REFERENCE: Arborist Response to City Review Comments RE: SUB22-009 (Cui Preliminary Short Subdivision)

SITE ADDRESS: 4833 90th Ave SE, Mercer Island, WA

DATE: 12/6/2023

This report addresses the City of Mercer Island's comments dated October 25, 2023.

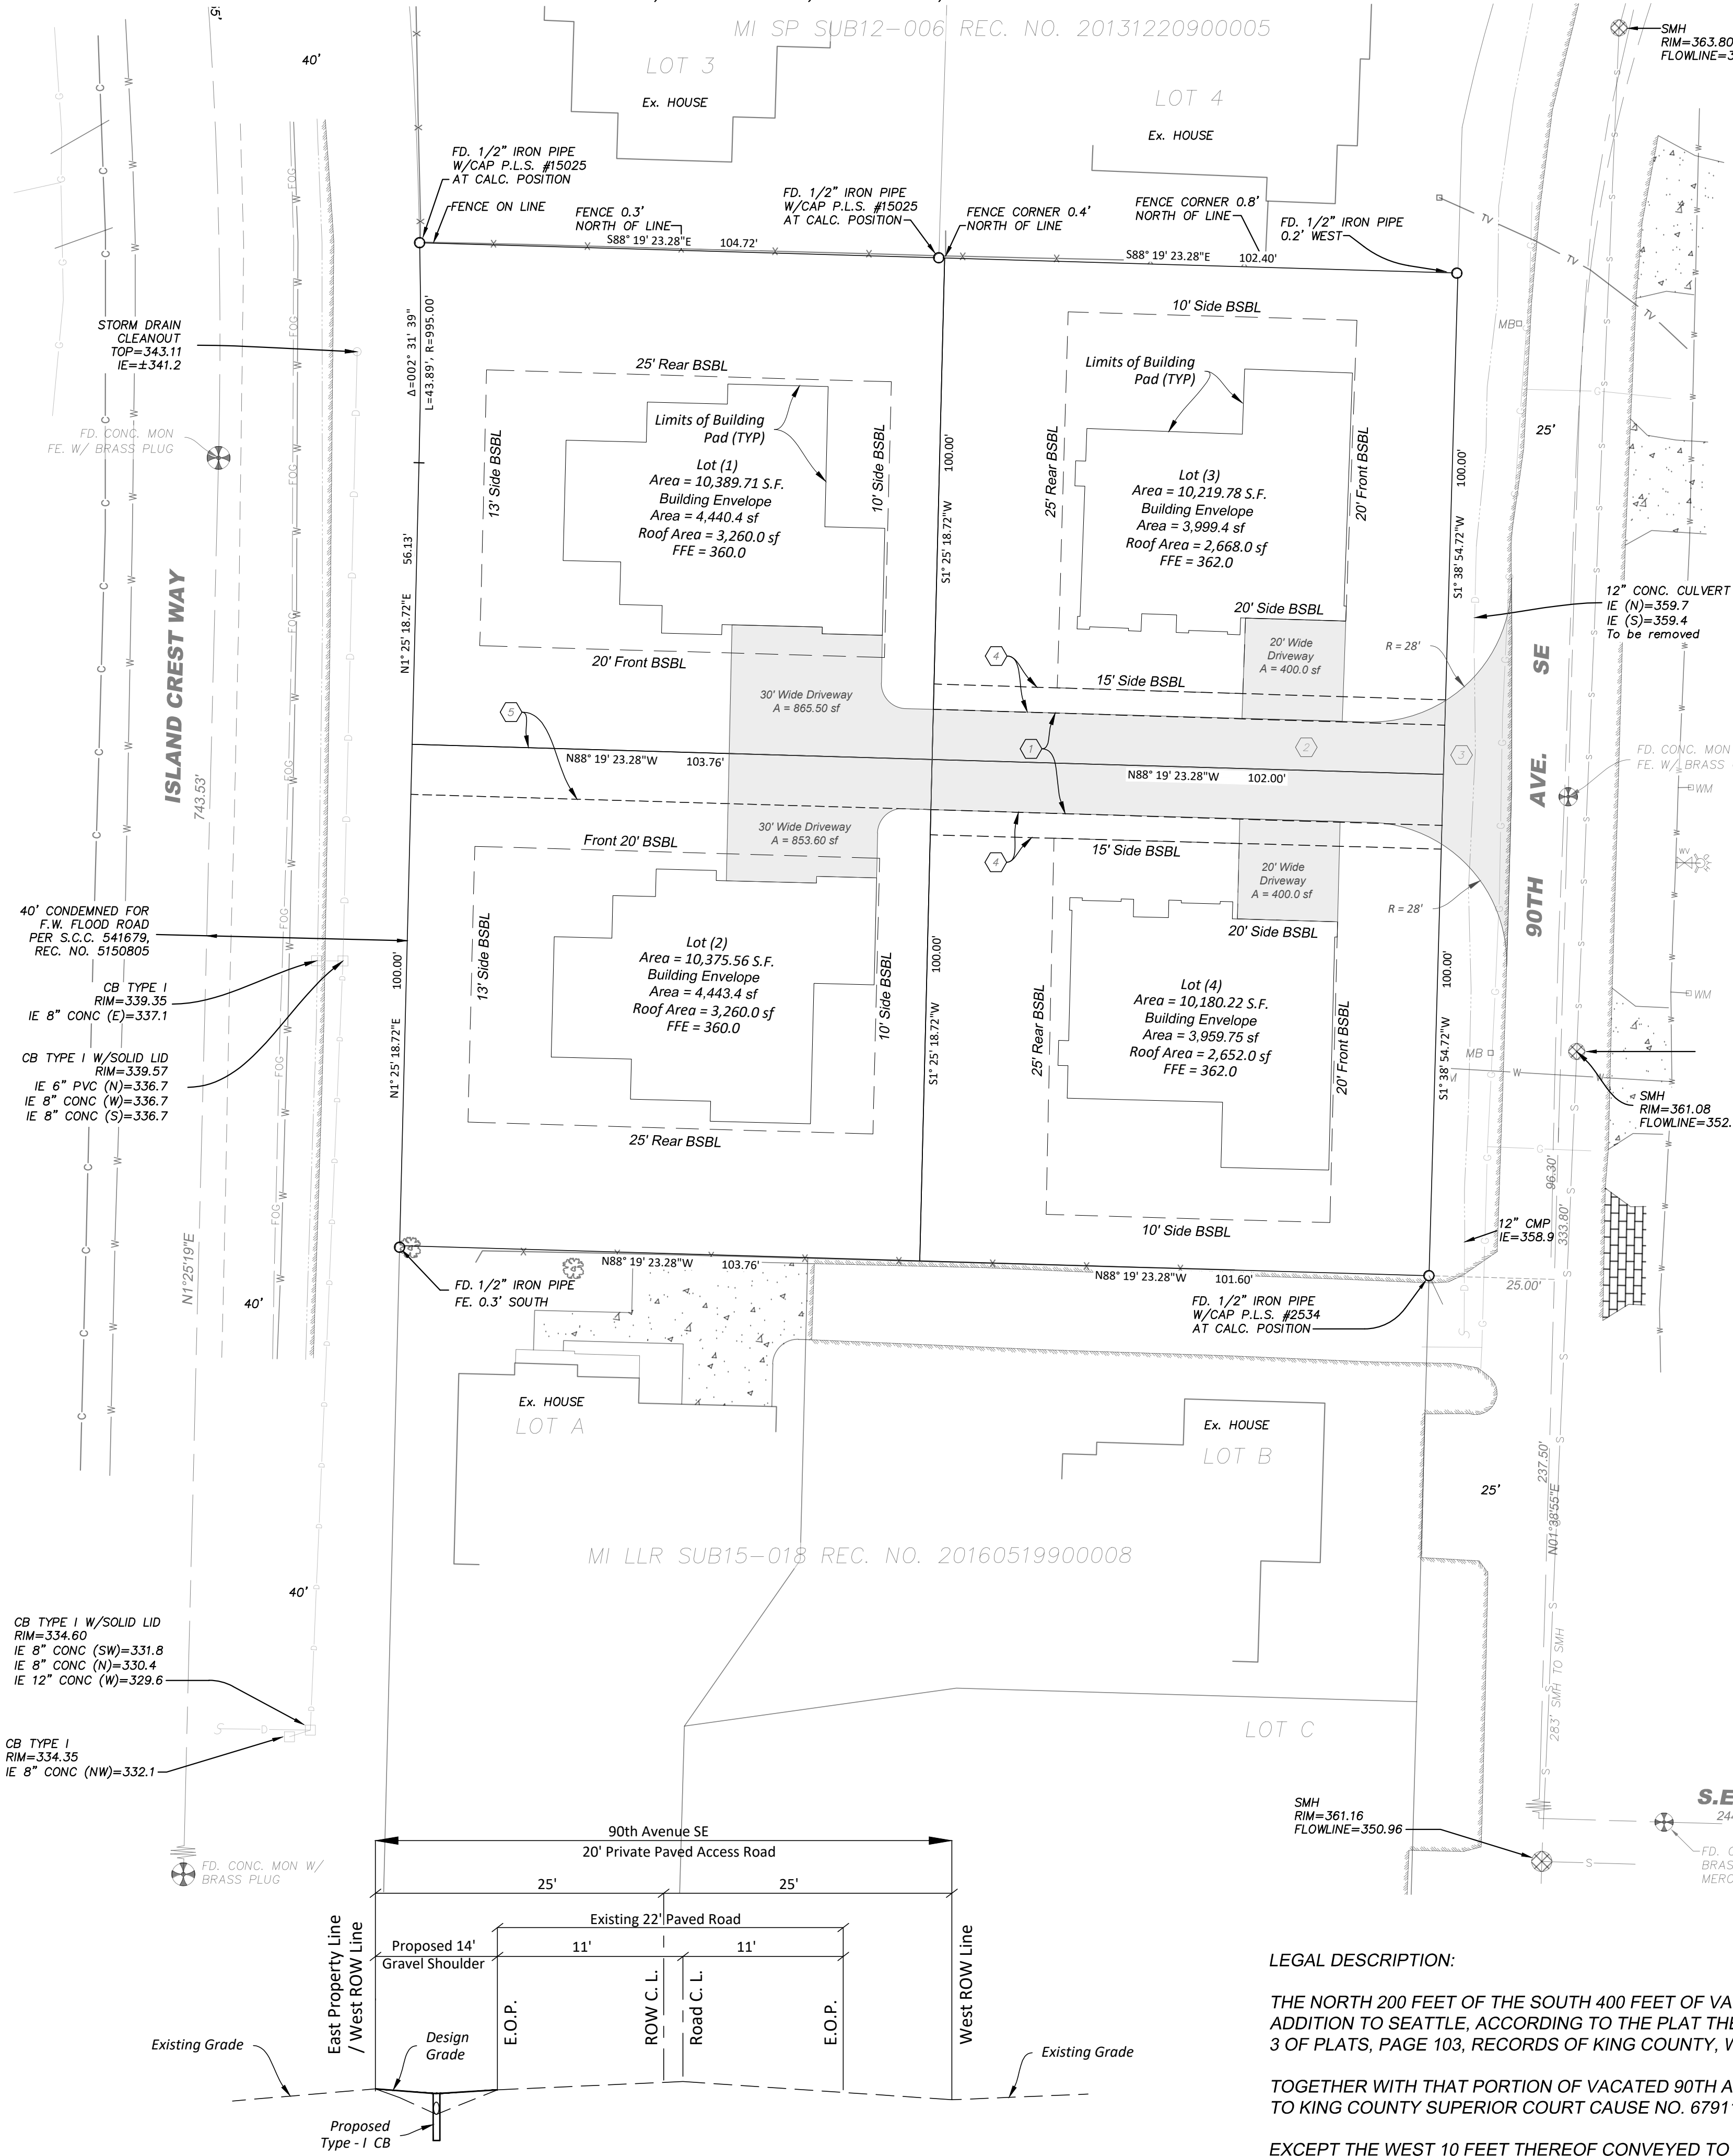
- b. Please show different options for lot line placements that retain the most exceptional trees or the exceptional trees most suitable for retention.**

- c. Determine the allowed setbacks and maximum gross floor area for each lot and configure the building pad to best avoid any exceptional trees and retain 30% of large trees. You may need to modify the rectangular building pads to accommodate exceptional tree driplines.**

- d. Please include an updated narrative and plan showing that you have followed the above steps. You may only remove an exceptional tree after this exercise takes place and you find that retaining the tree would limit the constructible gross floor area of a lot to less than 85% of the maximum gross floor area allowed in the zone.**

Arborist Response: See revised site plans showing smaller proposed homes to maximize tree retention.

Arborist Response: See revised site plans showing smaller proposed homes and non-rectangular homes to maximize tree retention.

Arborist Response: The project requests the removal of 4 healthy Exceptional trees 24" DBH or greater. Narrative is provided below detailing the site plan alterations that were considered to support retention.

Lot 1 – House footprint was shifted west to edge of buildable area and house footprint was reduced to retain Exceptional tree #s 63 and 68. Tree #63 is a 25.2-inch DBH Pacific Madrone tree located in the southeast corner of proposed Lot 1. The tree is proposed to be protected at its dripline to the north and east; however, encroachment is proposed to the south to construct the access road, detention tank, and associated catch basin. This work will occur 6 to 10 feet from the tree trunk. The existing single-family home is located about 8-feet south from the trunk of this tree; therefore, it is not anticipated that impacts from this work will substantially impact tree #63.

Lot 2 – House footprint was reduced to retain Exceptional tree #54 and large tree #s 51 and 52.

Lot 3 – House footprint was reduced and shifted further to the south outside of the driplines of Exceptional tree #s 4 and 5 and large tree #3.

Lot 4 – Grading was adjusted to preserve the dripline area west of large tree #36. The city is requiring a 12" storm pipe be constructed to the east of tree #36 to pipe the existing ditch. Tree protection fencing is shown to extend 7-feet to the east at the limits of disturbance for this utility work. This species of tree has a high tolerance to construction impacts and, due to its young age, should be able to tolerate this level of impact. To ensure adequate protection, any utility work within the dripline shall be monitored by the project arborist.
